Rep for BR/75/20/HH

Subject: Application PP-08589020.

PROPOSED PLANS AND ELEVATIONS

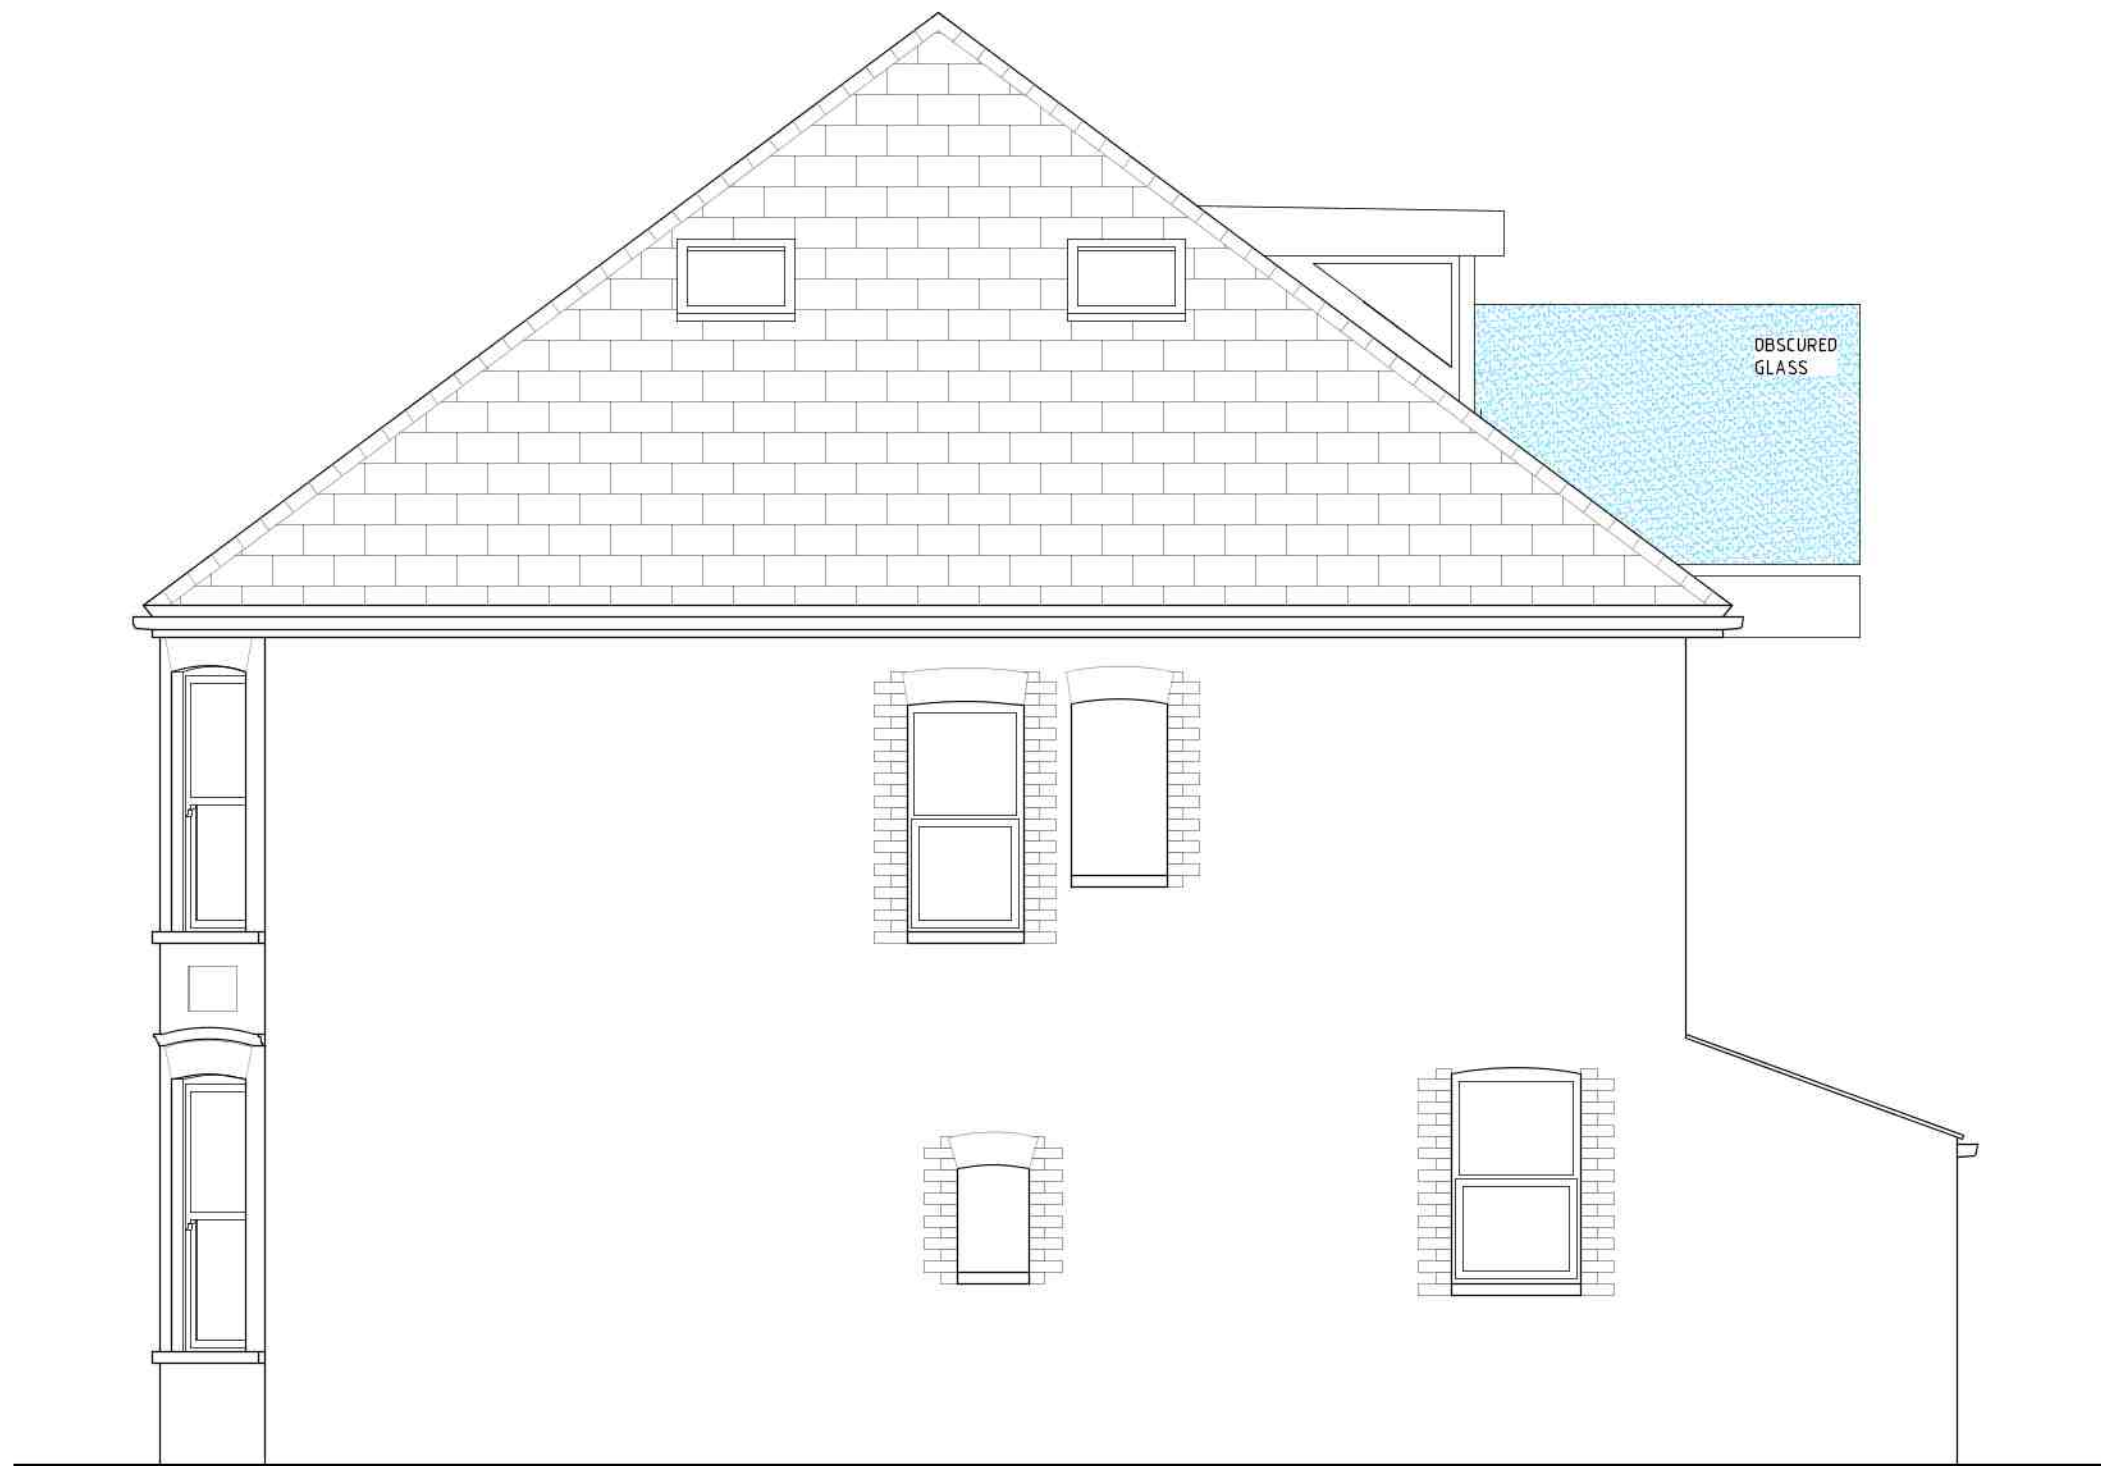
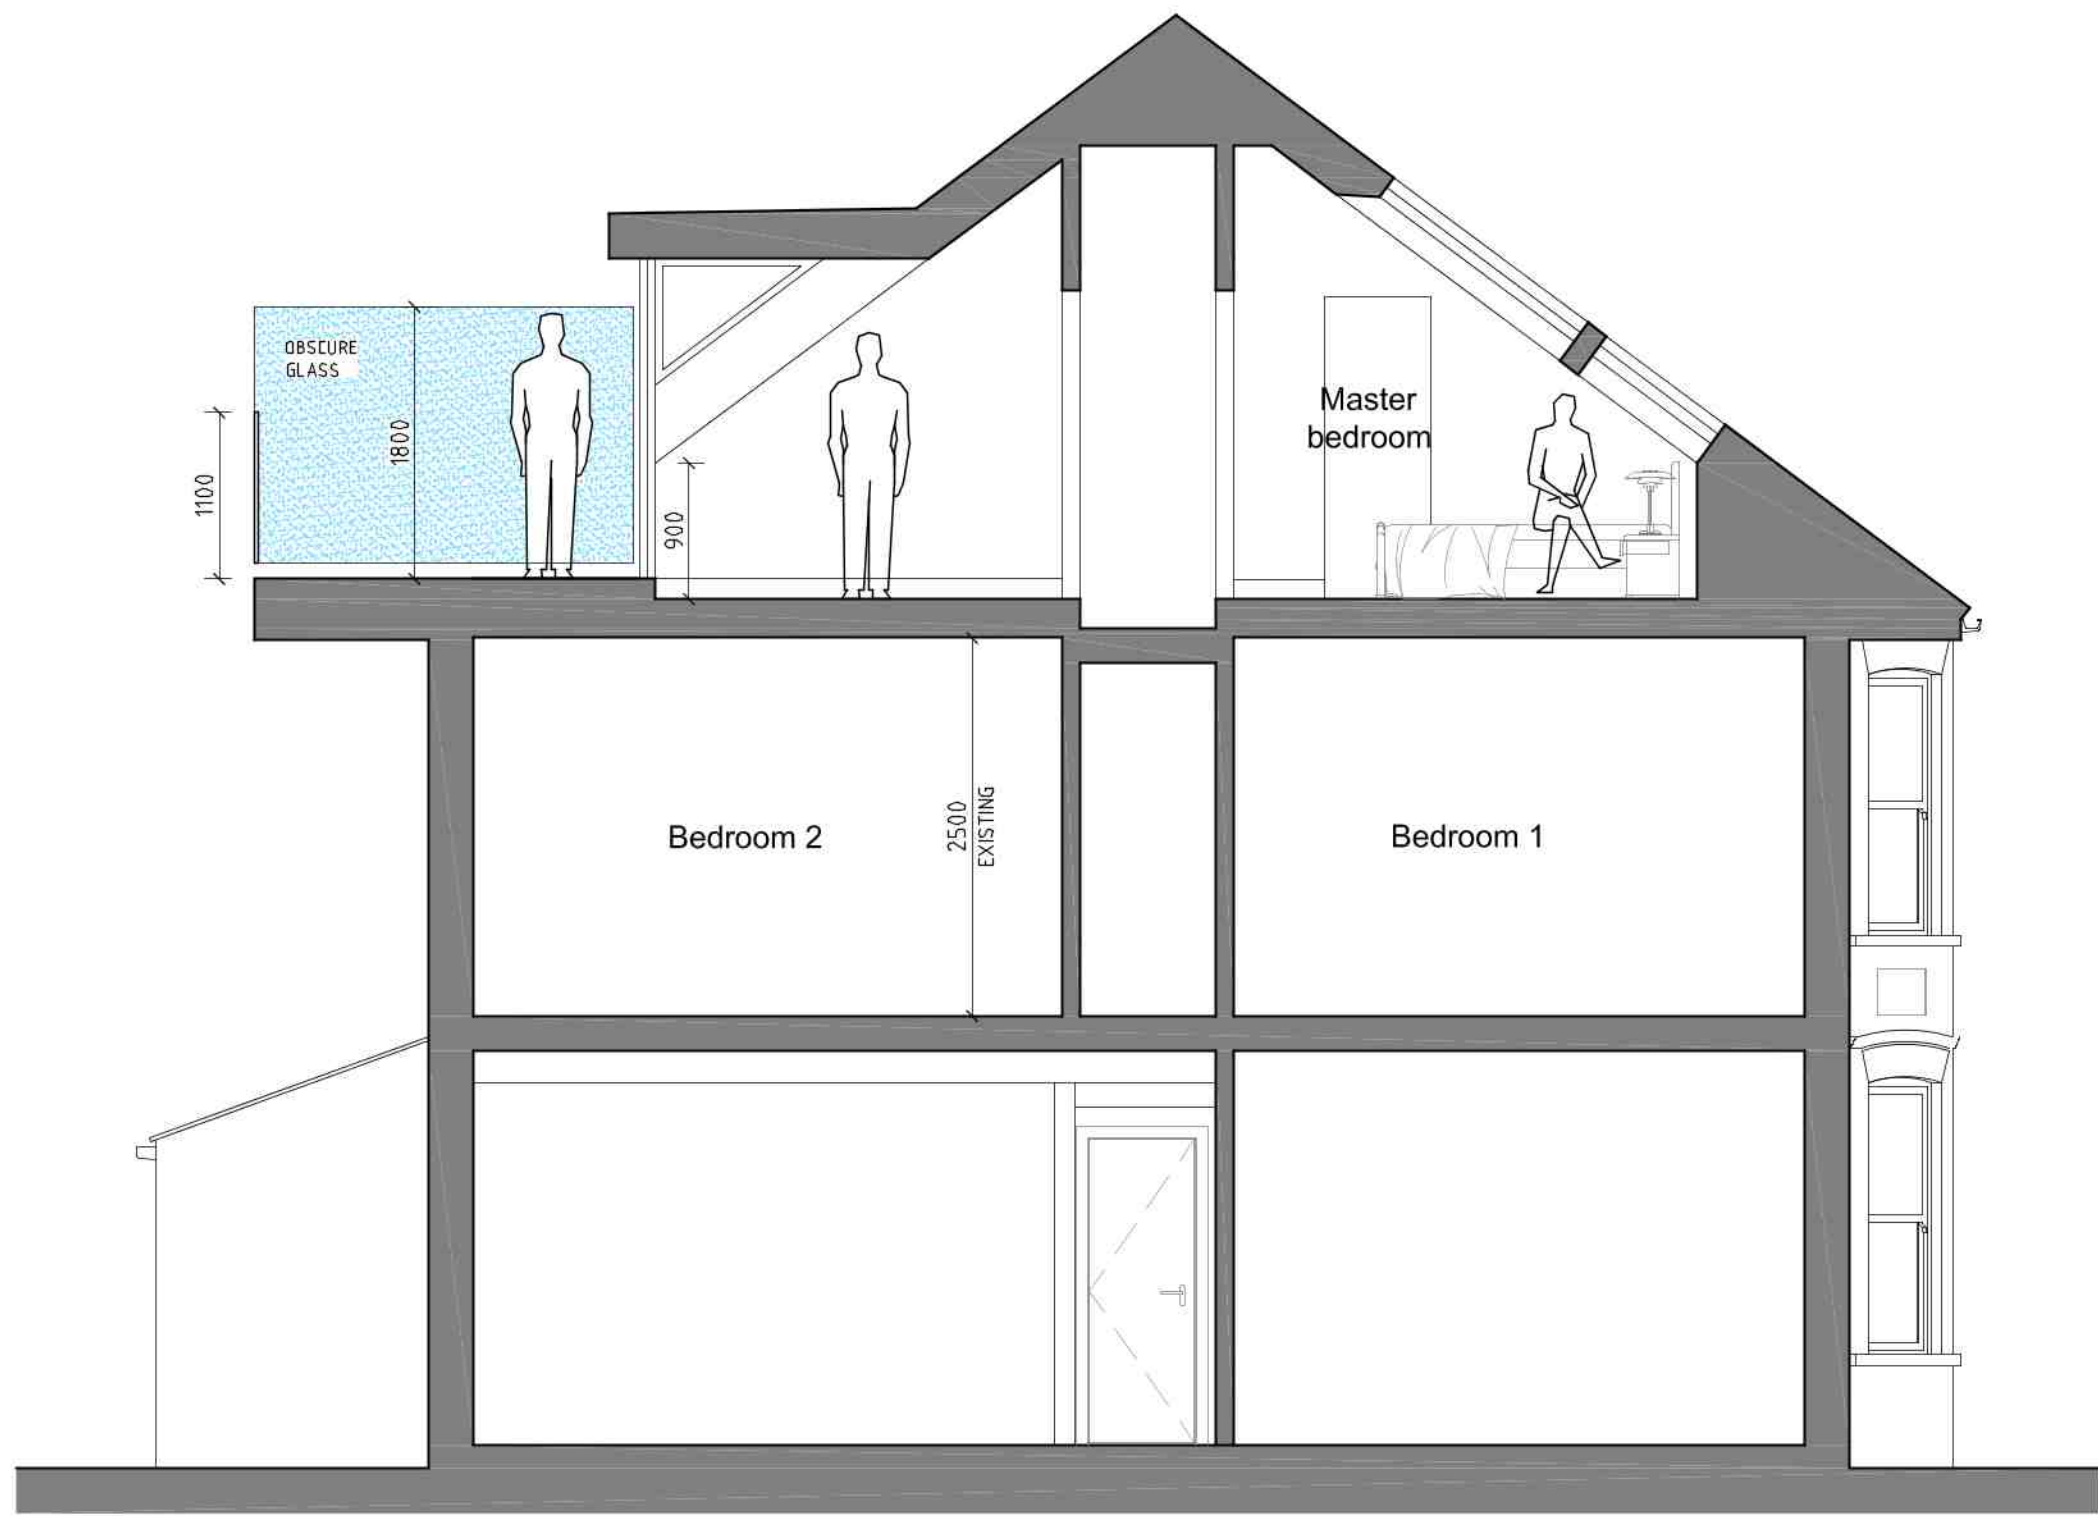
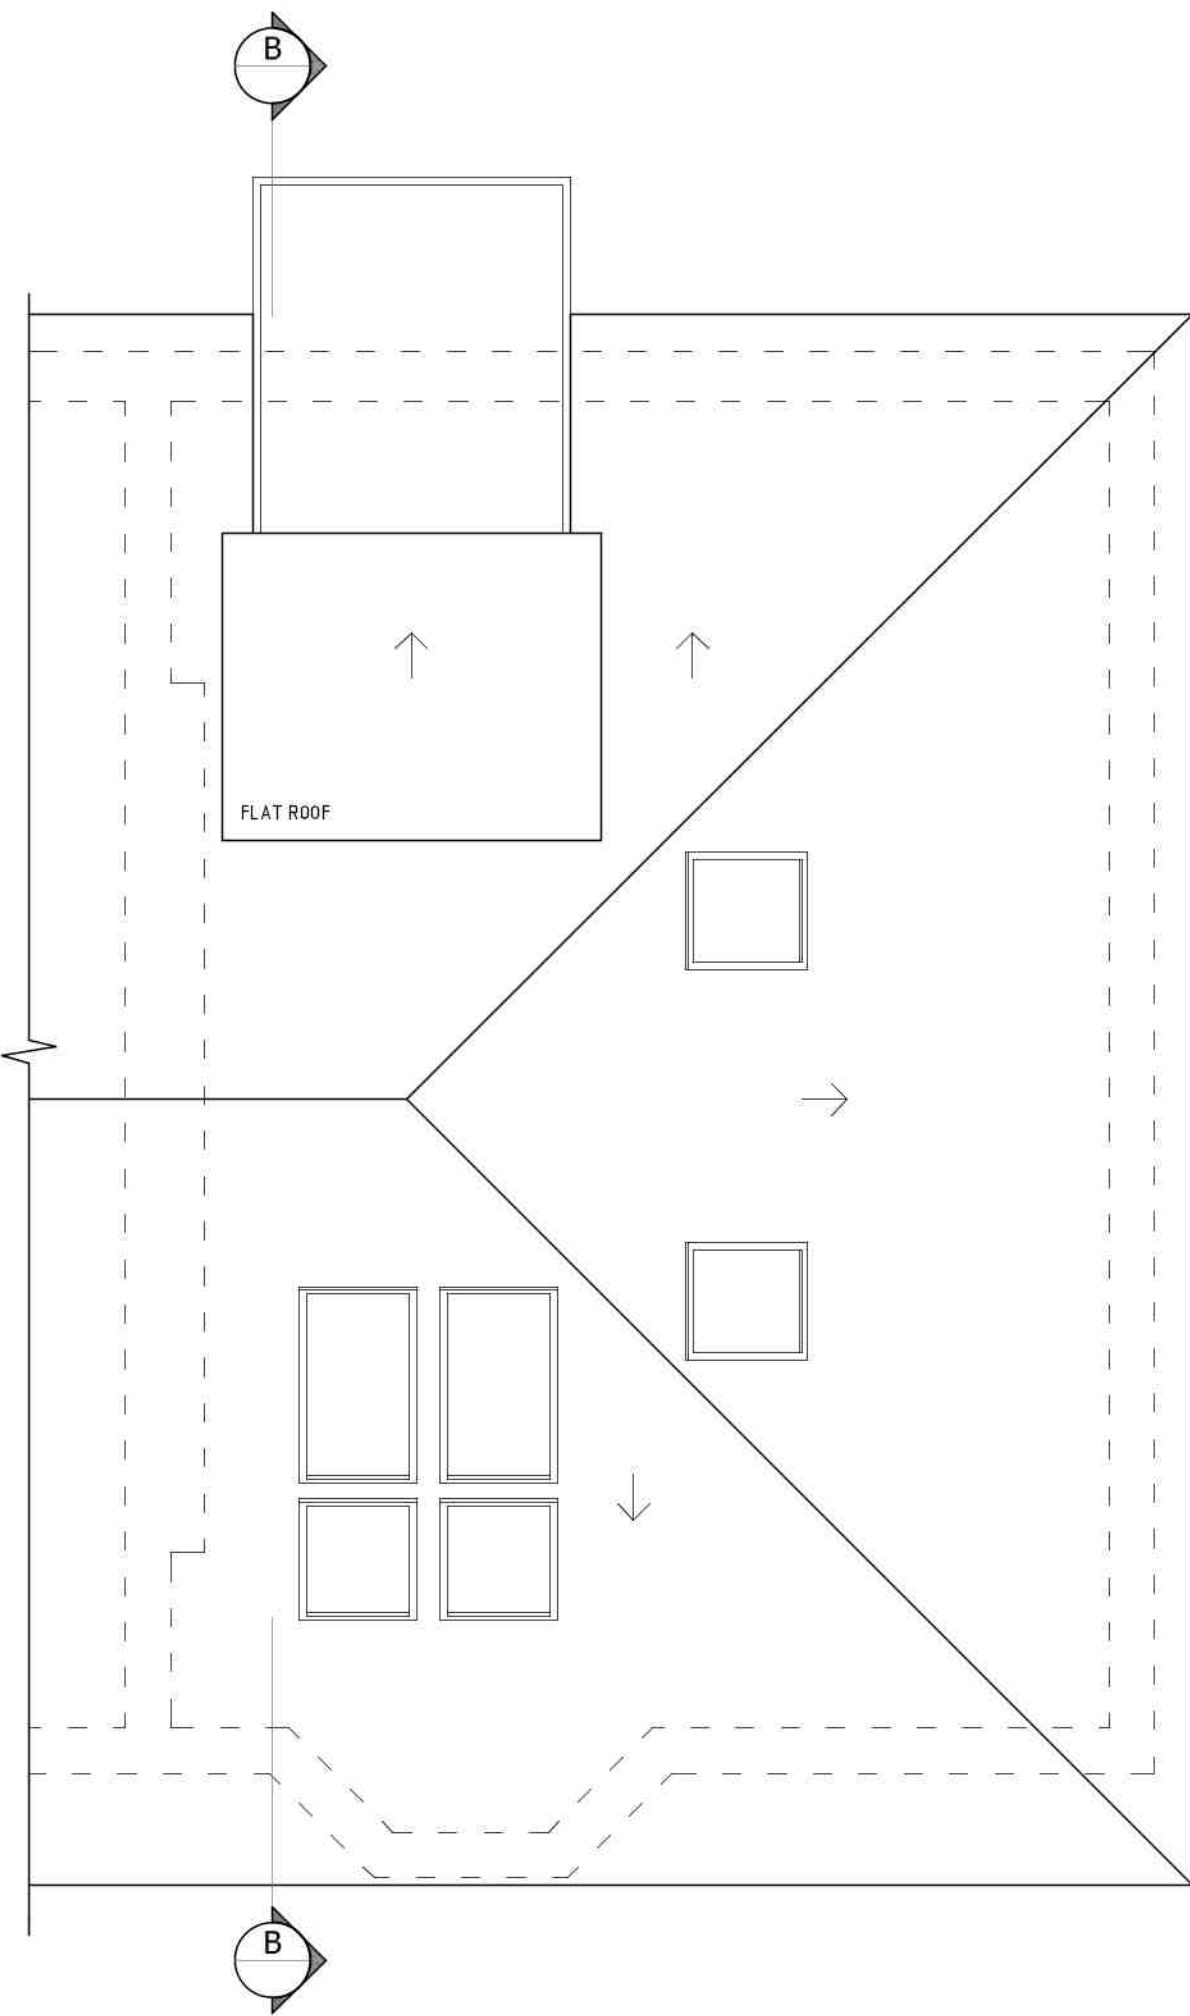
My name is Mrs E Steel.I want to lodge an objection to the above application. I live in Spencer St almost opposite No.140. My concern is my privacy. From the proposed balcony you would be able to look into my bedroom,dining room,garden and conservatory.
